Notice of Exhibition of application for Kamay Ferry Wharf Project (SSI-10049)

Thank you for your referral dated 12 July 2021 inviting comments from the Heritage Council of NSW on the above State Significant Infrastructure (SSI) proposal.

As delegate of the Heritage Council of NSW, I provide the following comments:

Figure 5-16: Temporary causeway (Kurnell)

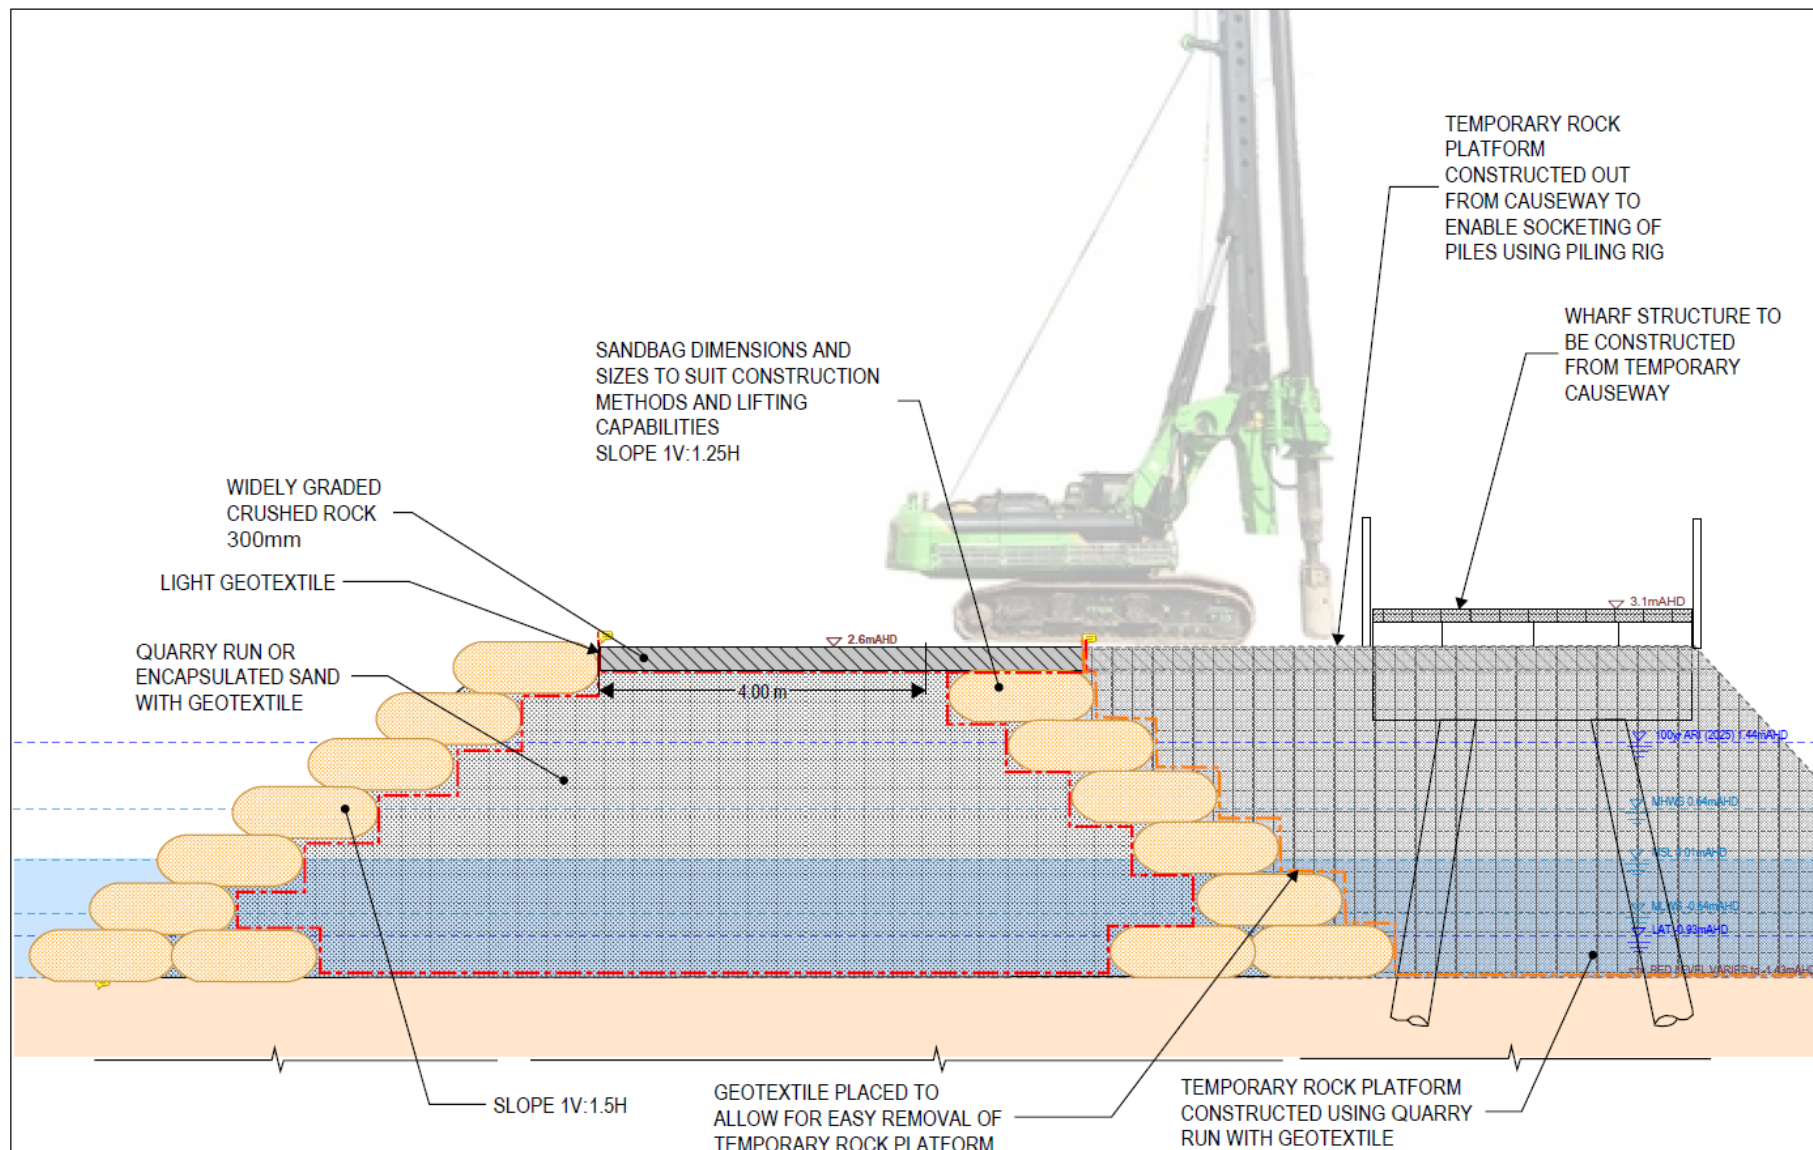
- b) The Kurnell wharf piling is within 5-10m of the coursed stone sea wall. There are parts of this wall no longer mortared together and in disrepair. Remedial work to mortar, repair and support these sections is required, before and during piling;
